**HYDROLOGY DEVELOPMENT SECTION
DEVELOPMENT REVIEW BOARD MEMO**

DRB PROJECT NO: 1009178

Preliminary Plat approval

RE: Lots 6 & 31, Block 9, Volcano Cliffs Unit 18

**TIBURON HEIGHTS  
SIDEWALK DEFERRAL EXHIBIT**

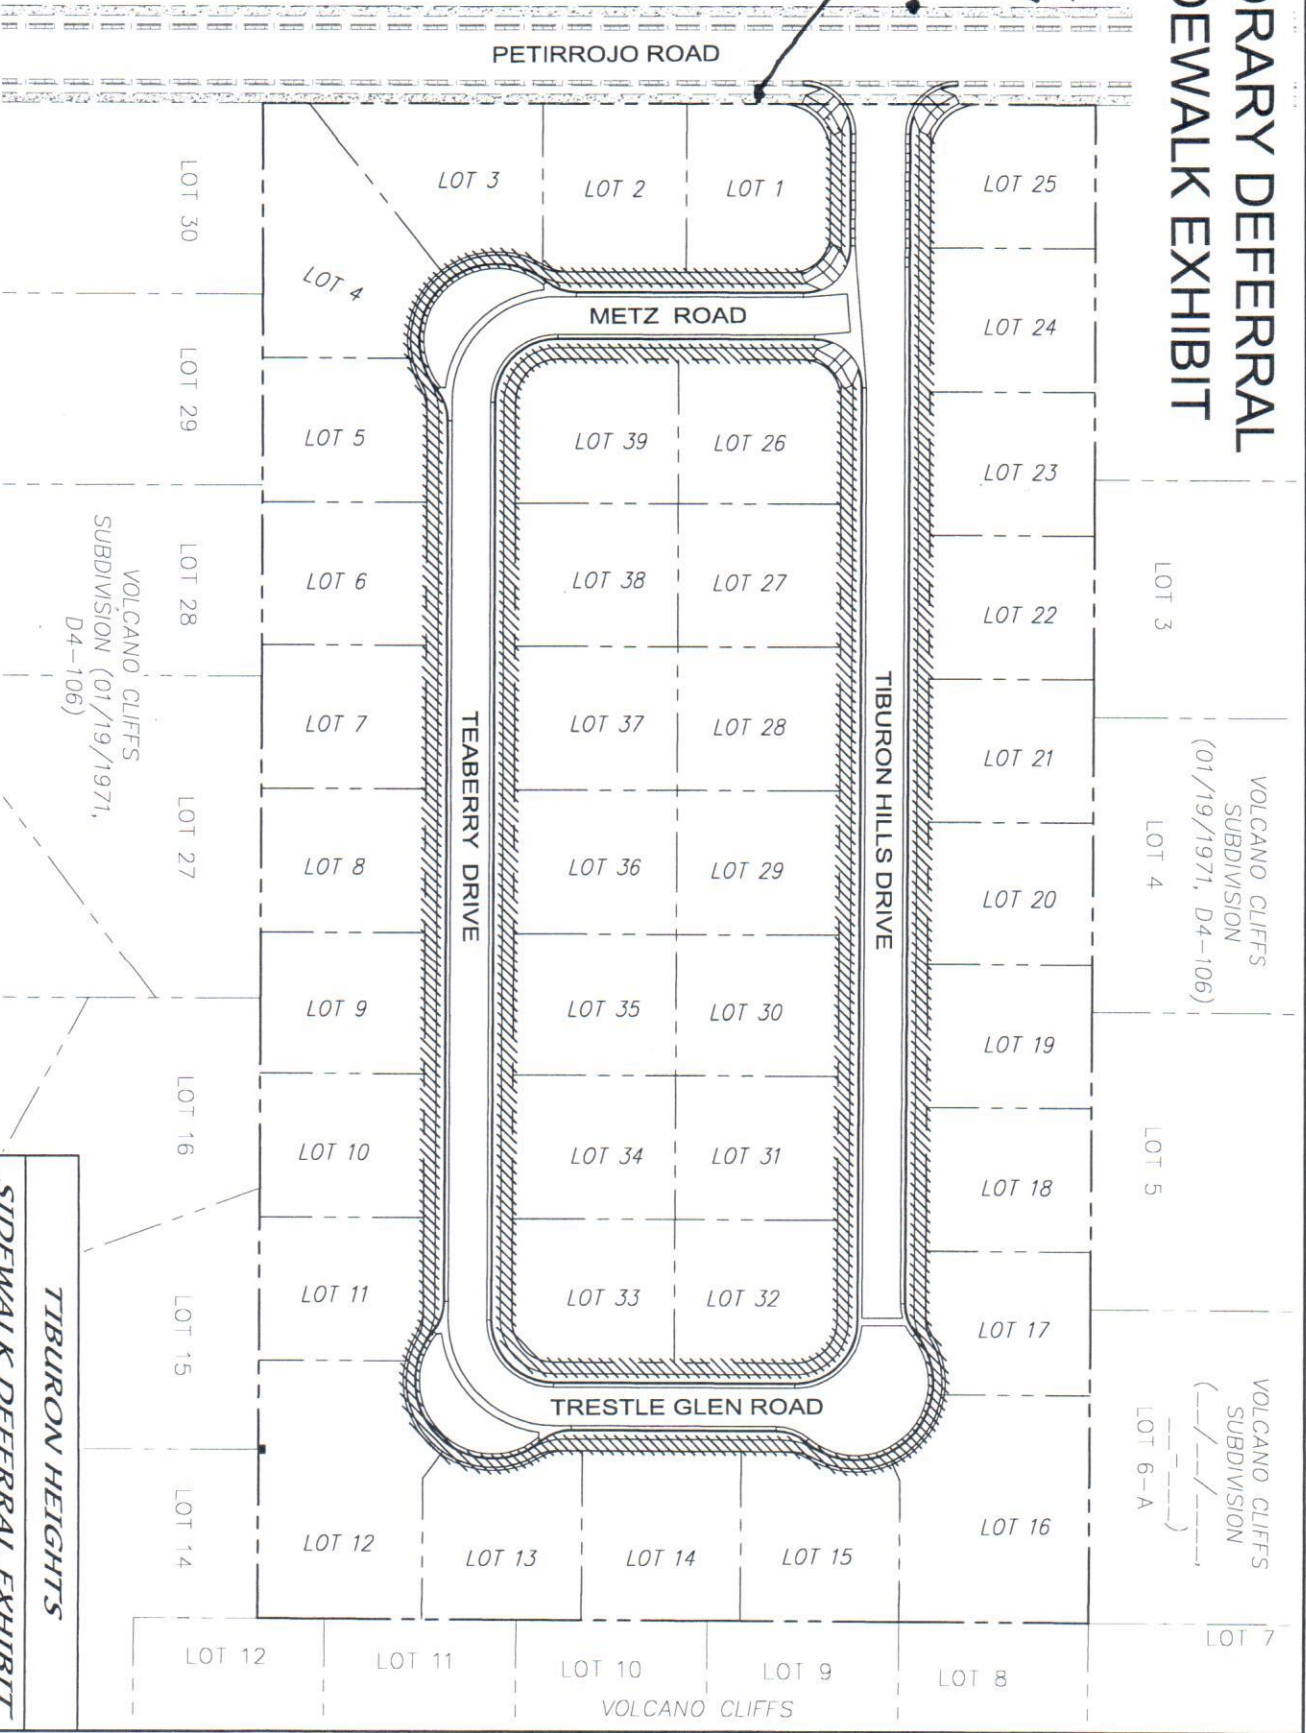
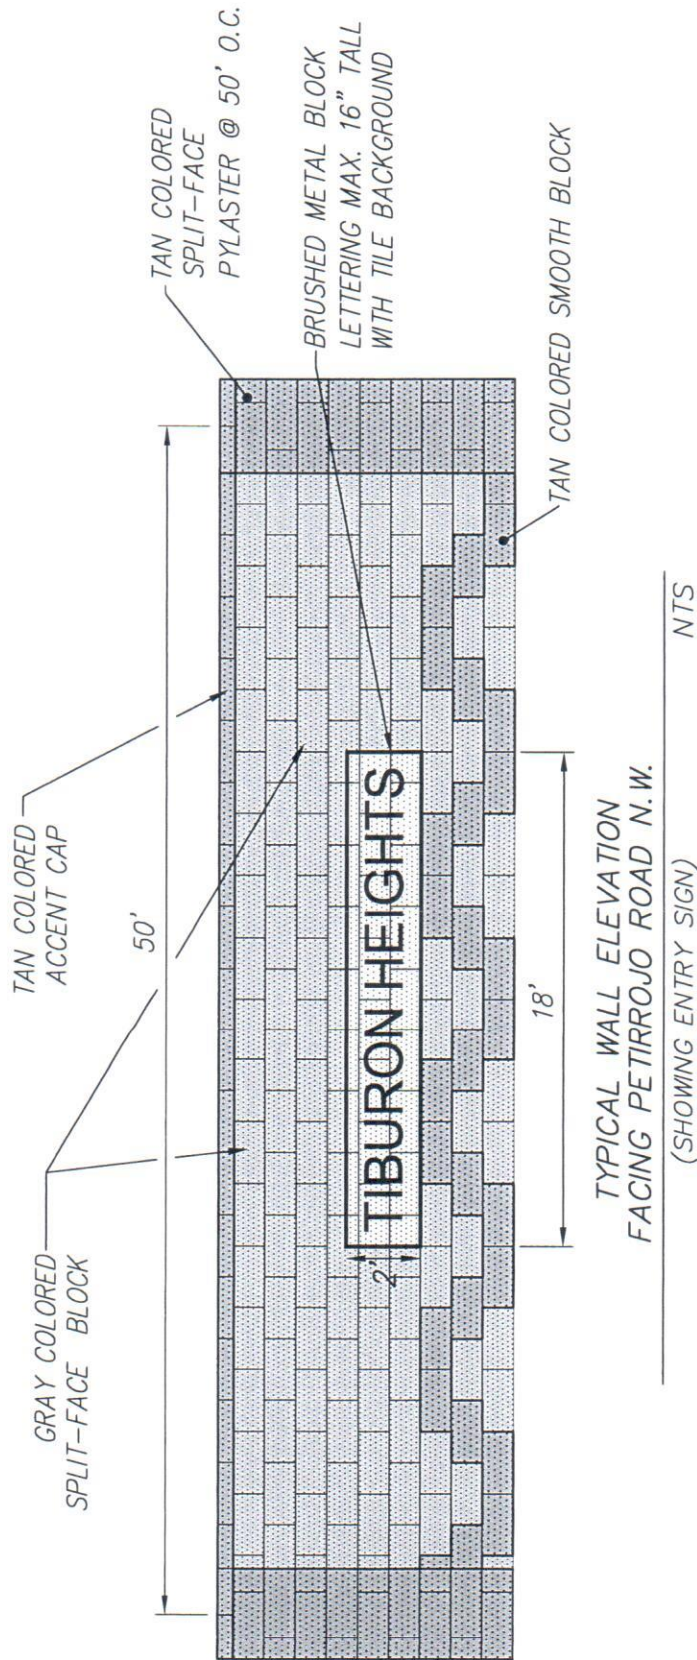
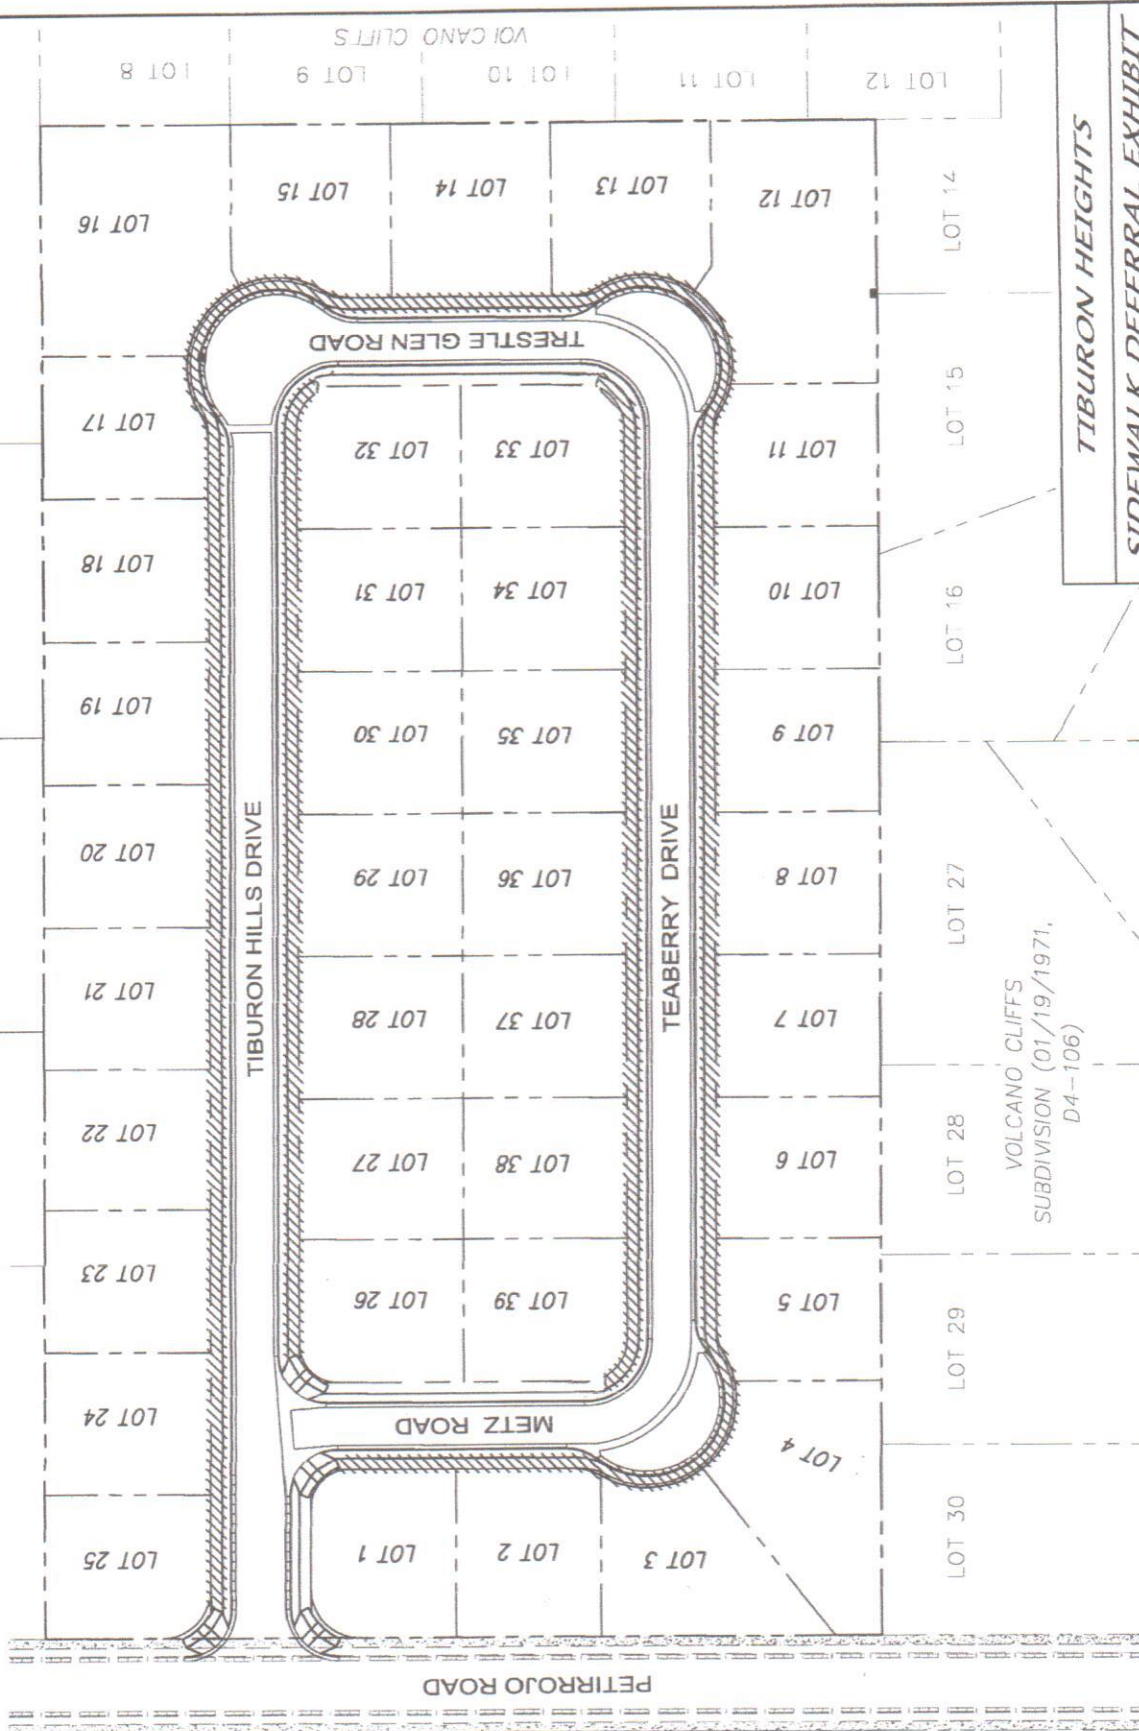
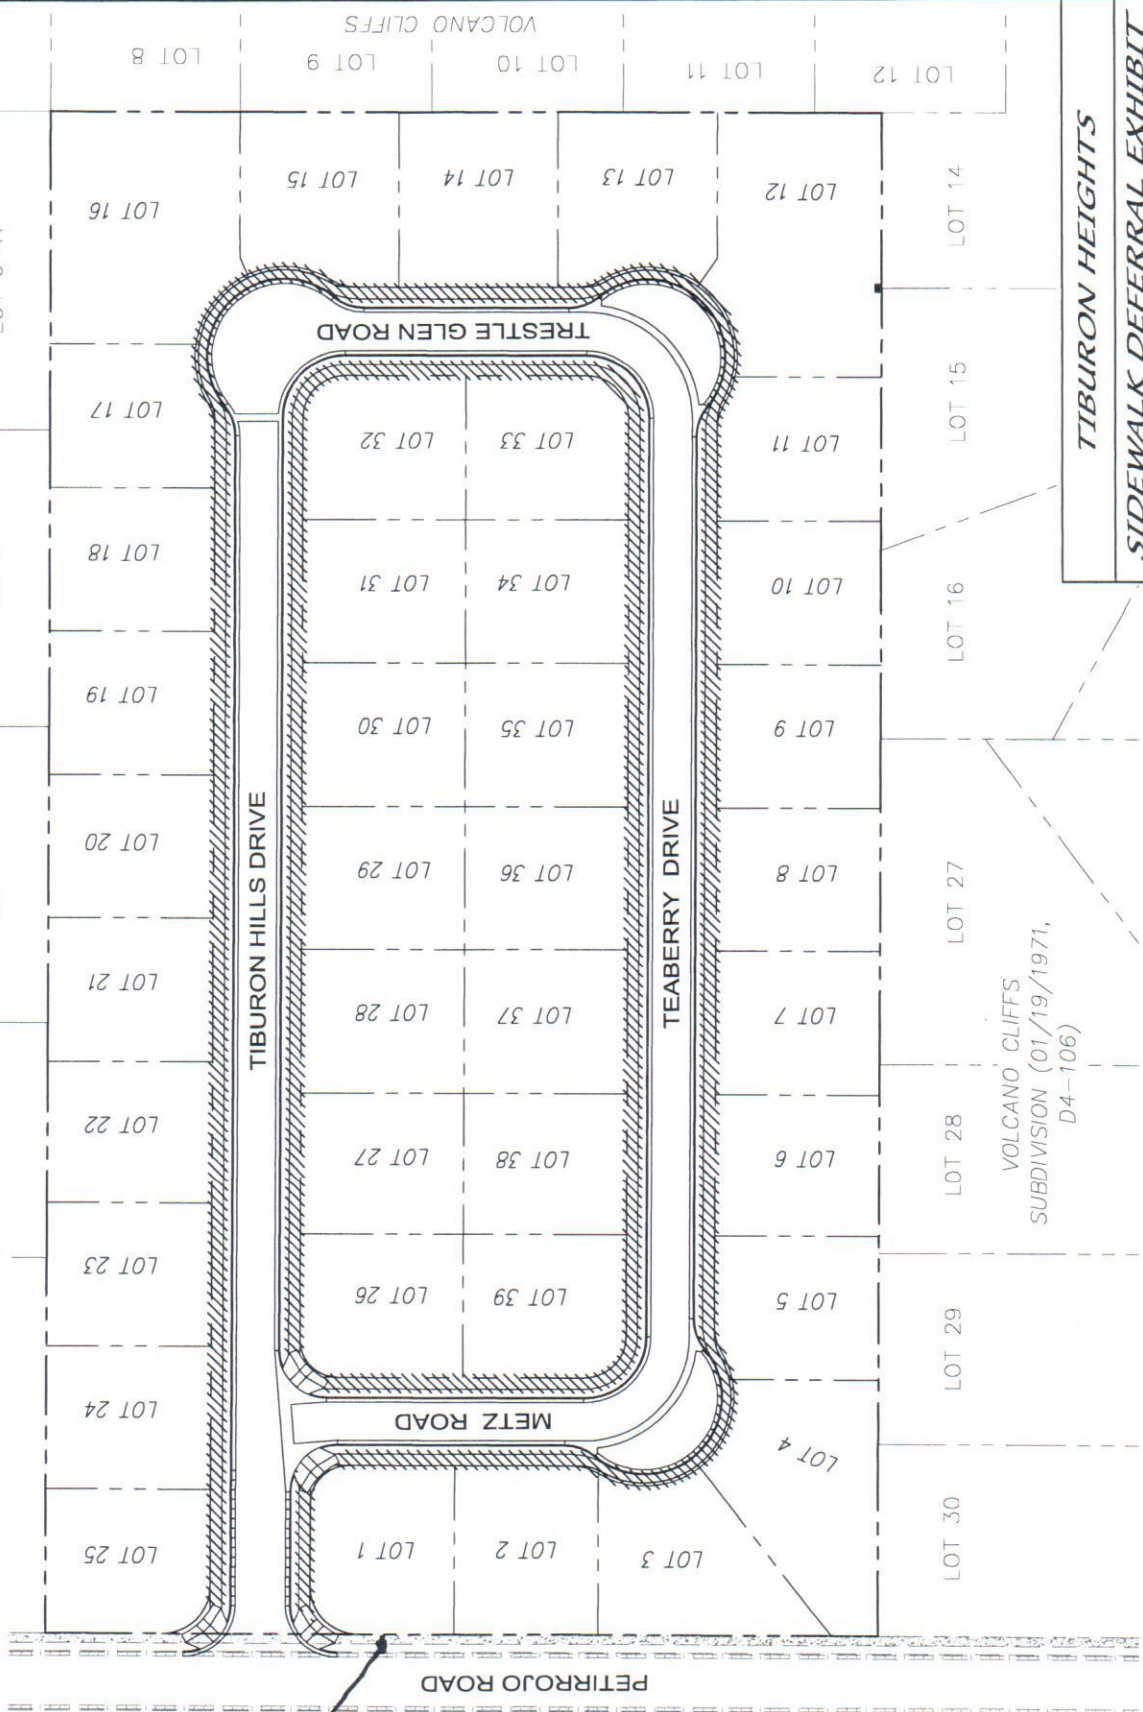
Provide an exhibit showing the location of sidewalk and defining the distance from face of curb to the property line. Right of way dedication may be required.
The vacation of an easement requires a vacation request.

Provide an exhibit showing the location of sidewalk and defining the distance from face of curb to the property line. Right of way dedication may be required.
There is no sidewalk along Petirrojo Road; sidewalk must be constructed with this project. An infrastructure list will be required.
No objection to vacation request.
